CITY OF ALBUQUERQUE

August 7, 2013

Re: Tiburon Heights Subdivision, Drainage Report
Engineer's Stamp date 6-24-13 (D10D003A)

SCALE: 1"=50'
INTERIM PLAN FOR TEMPORARY
PONDING ON LOTS 1, 2 AND 25

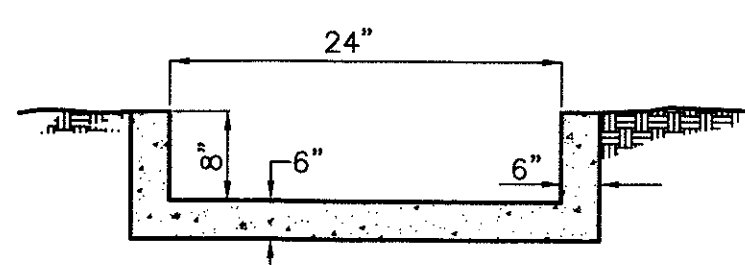
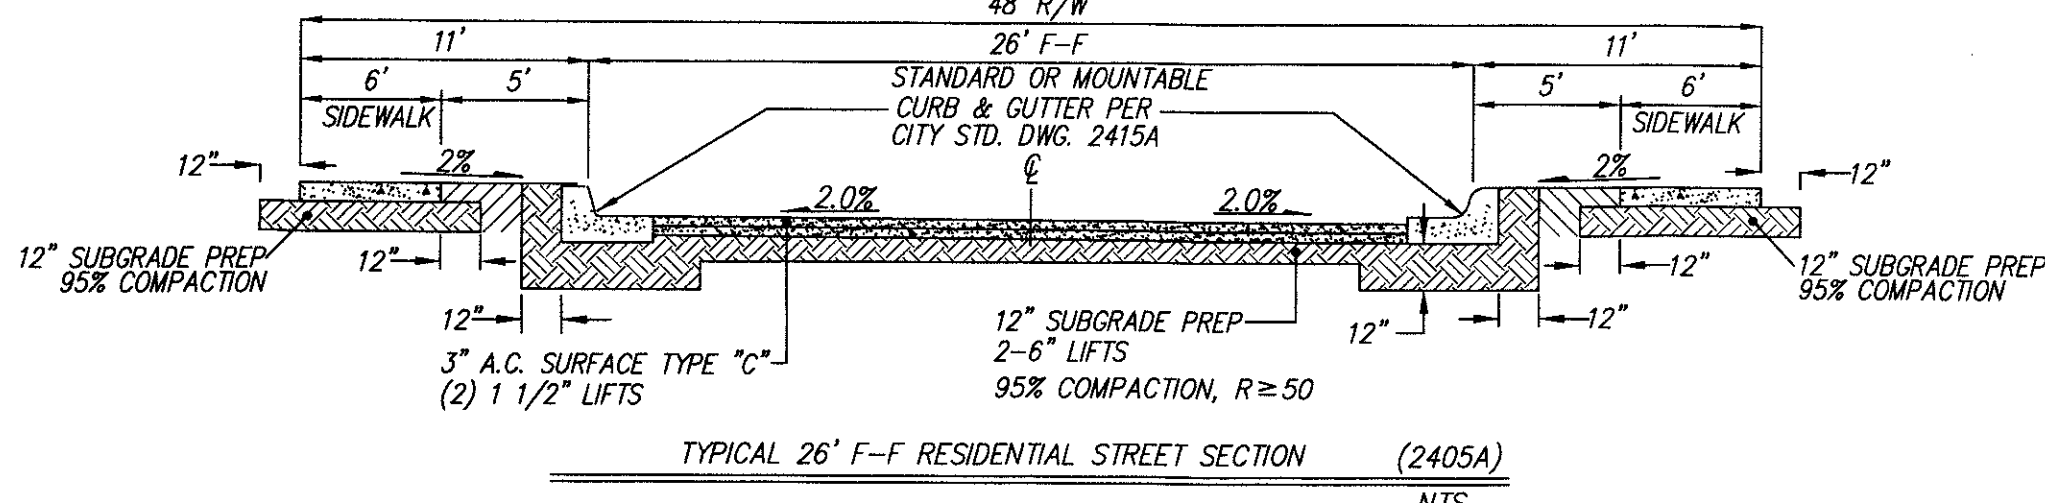
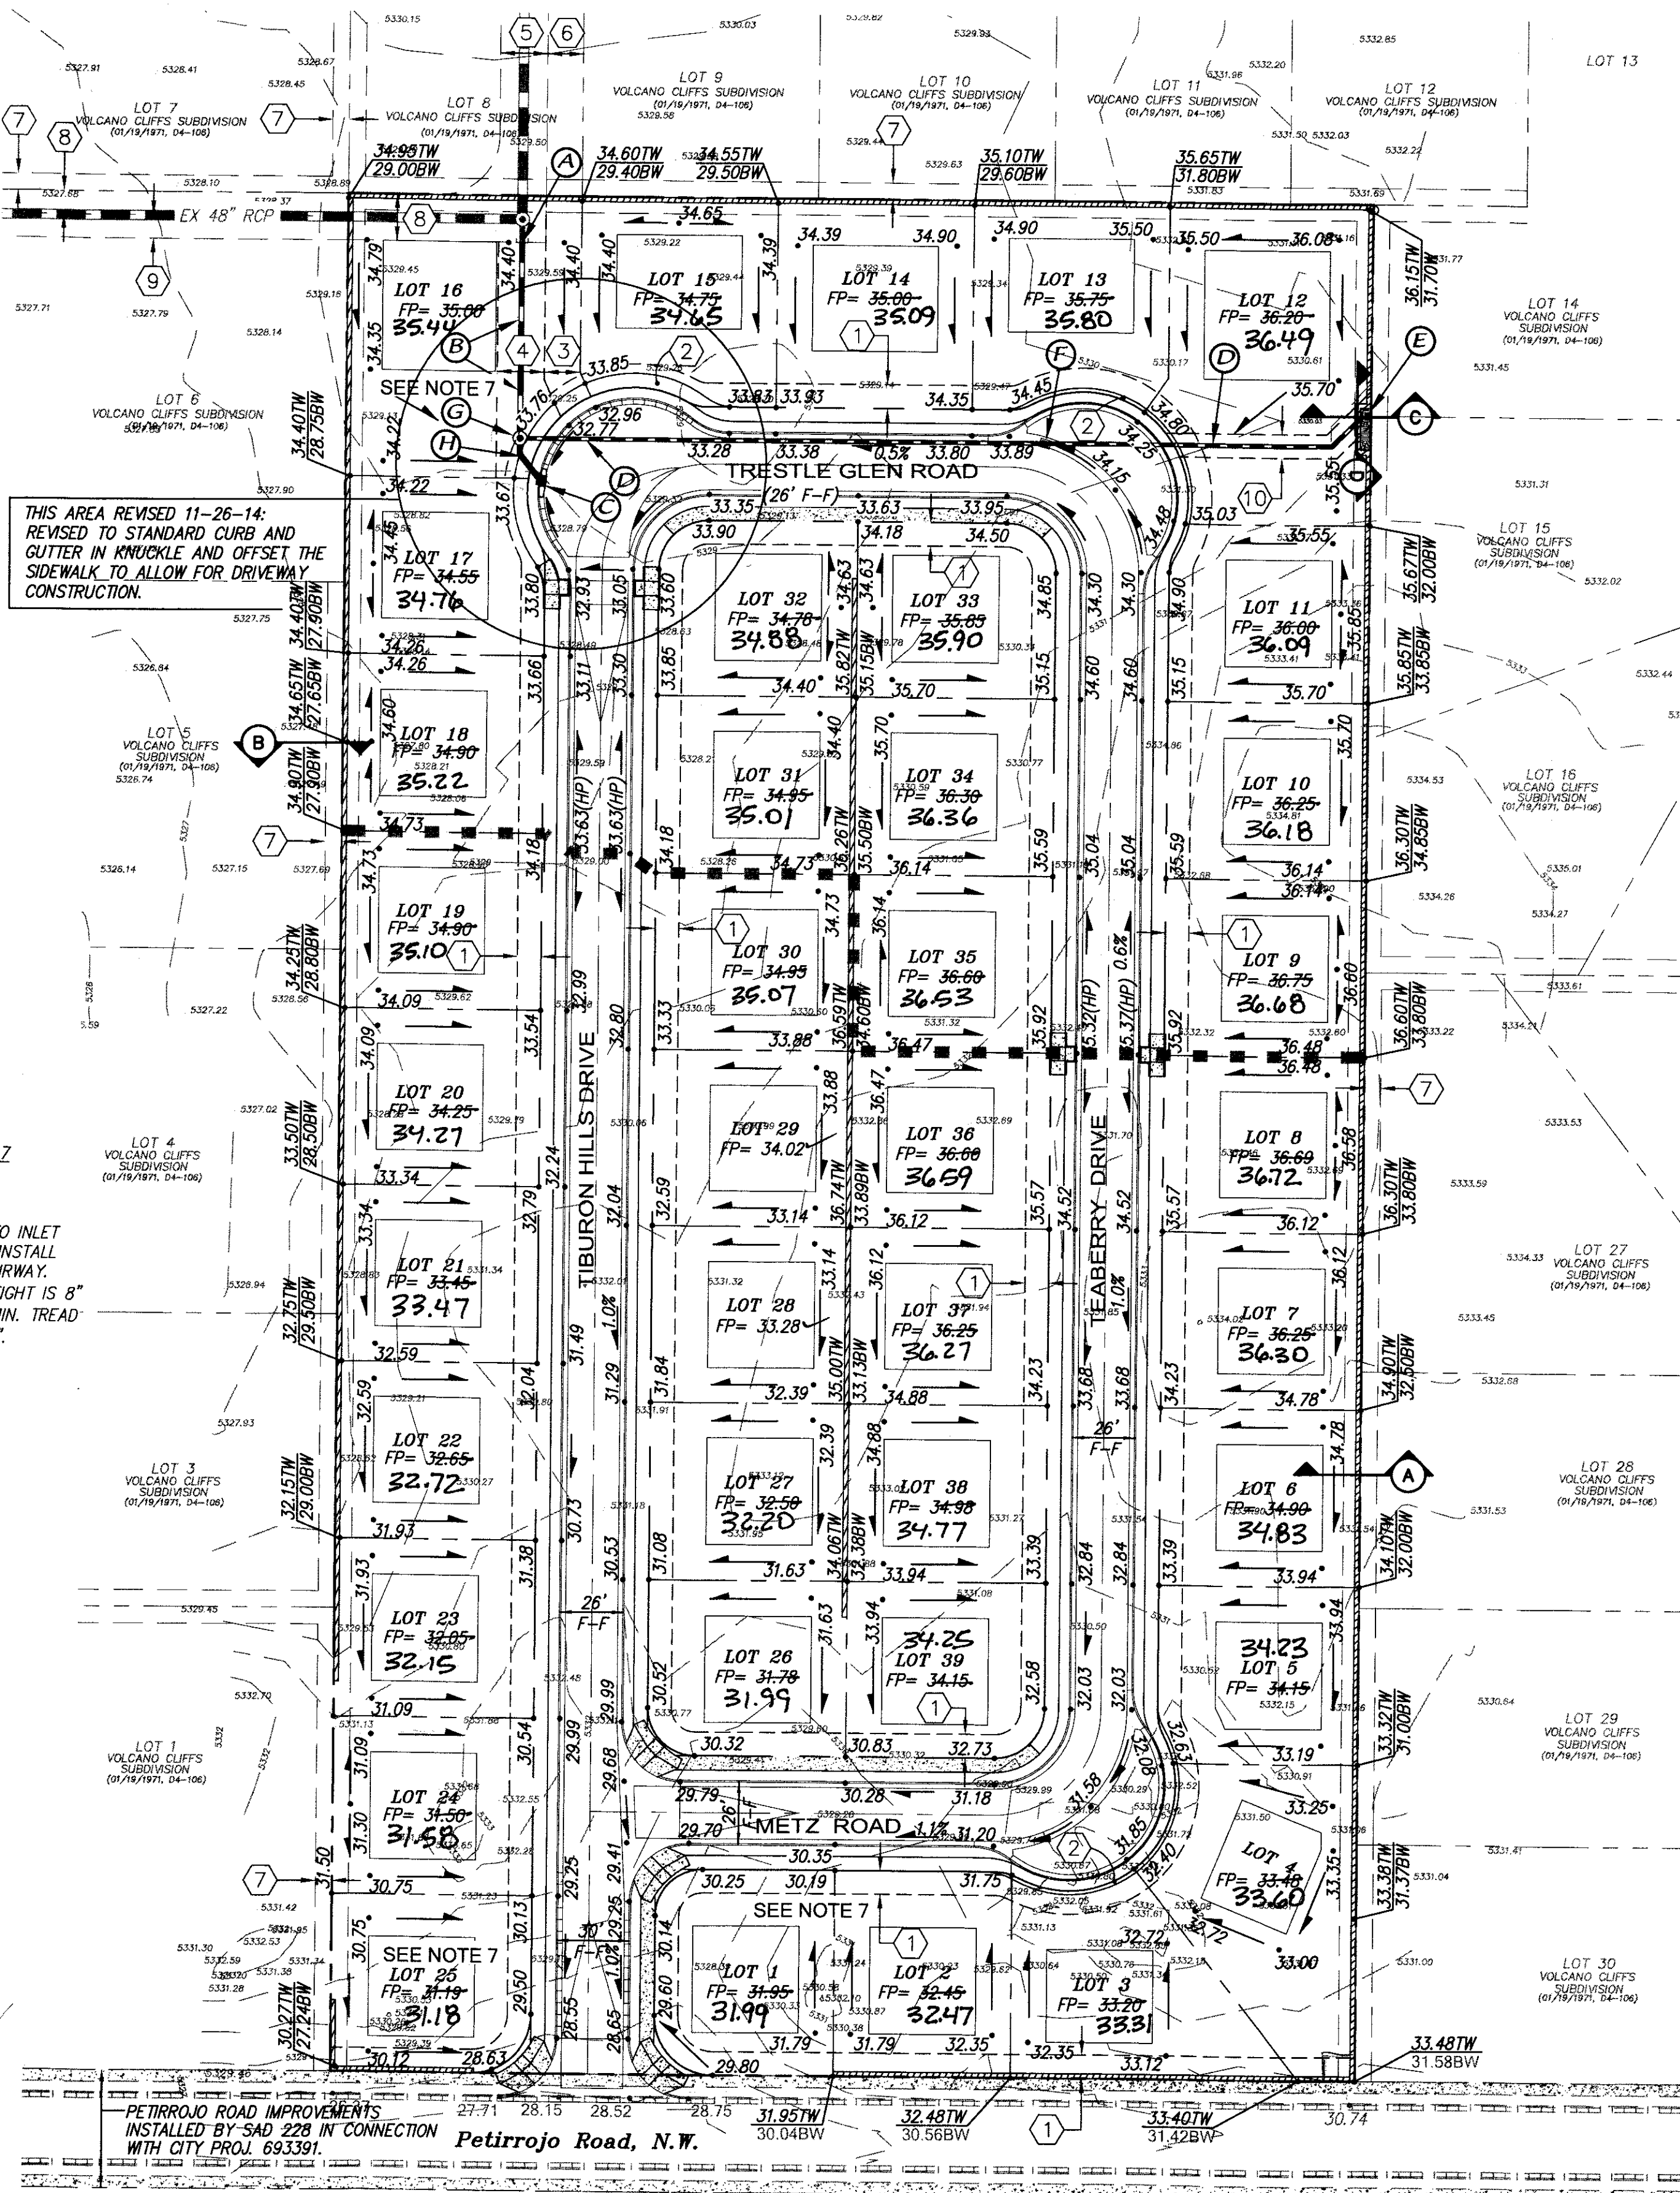
1. Since the downstream drainage infrastructure has not been constructed, the drainage report should include an interim plan that proposes temporary retention ponds. Please include an interim plan and a final plan.

2. A public drainage easement with an agreement and covenant is required for the temporary ponds. These items should be listed on the infrastructure list.

TITLE: *TIBURON HEIGHTS
GRADING AND DRAINAGE*

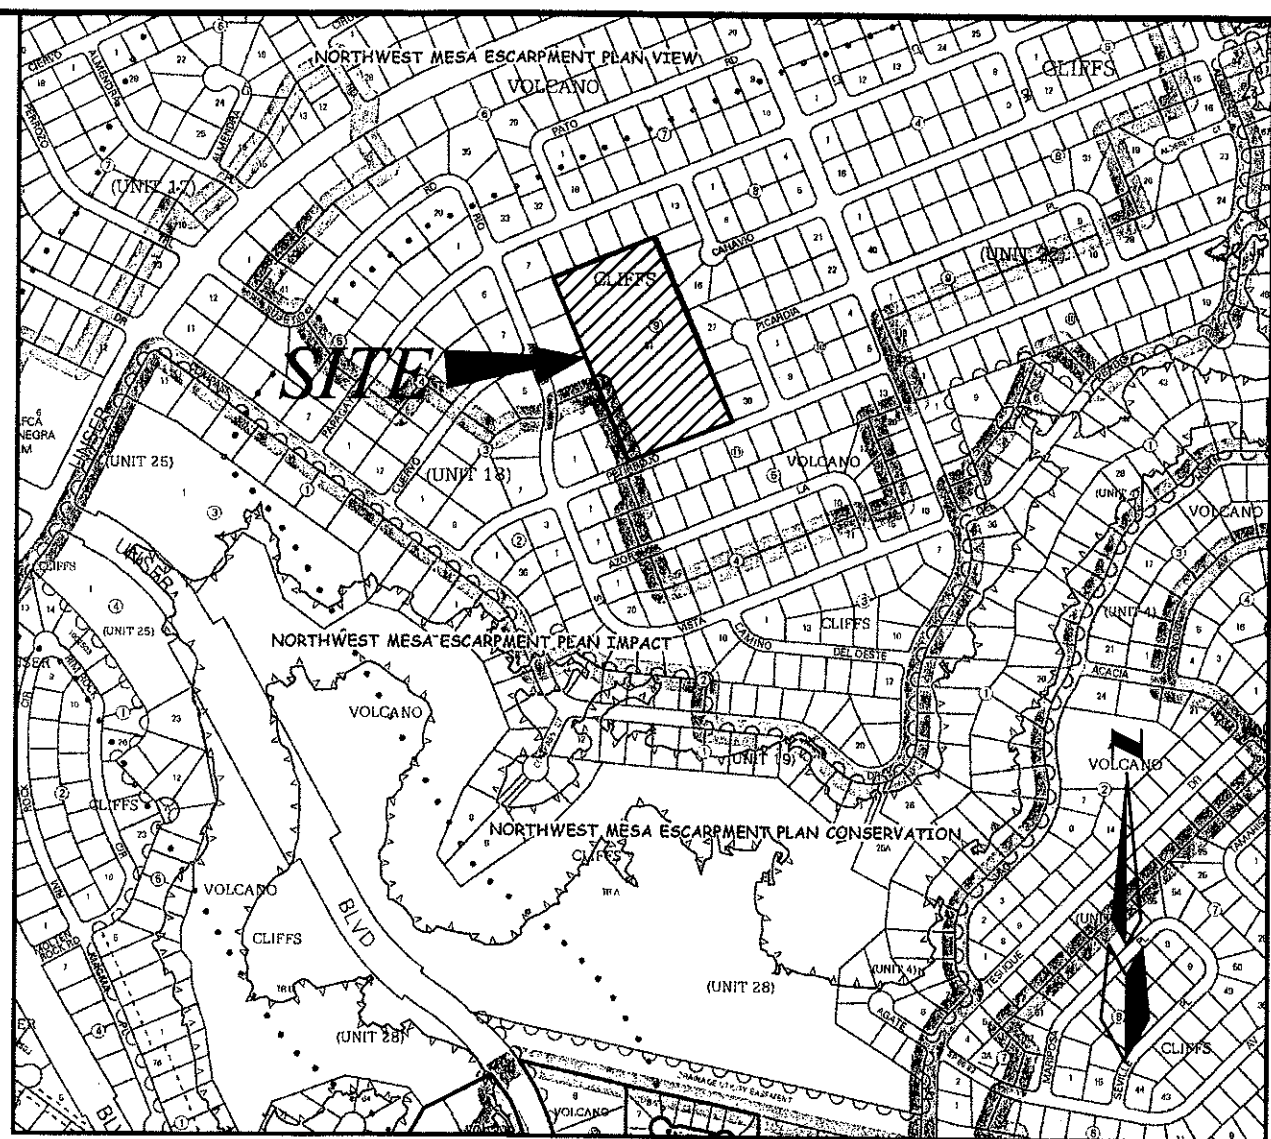
3. The storm drain serving the offsite basin is private. It is not standard to have a private storm drain run longitudinally in the street. In addition, this would require a license agreement. As discussed, a "D" inlet could be proposed in the flow line near Lot 12 and the storm drain upsized to an 18" RCP minimum based upon hydraulic capacity.

4. The inlet on Lot 12 will be maintained by the owner of Lot 12 (please add a note to the plat). As discussed, a stairwell could be proposed on the grading plan to allow for maintenance of the inlet. Include a detail of the stairwell or similar.
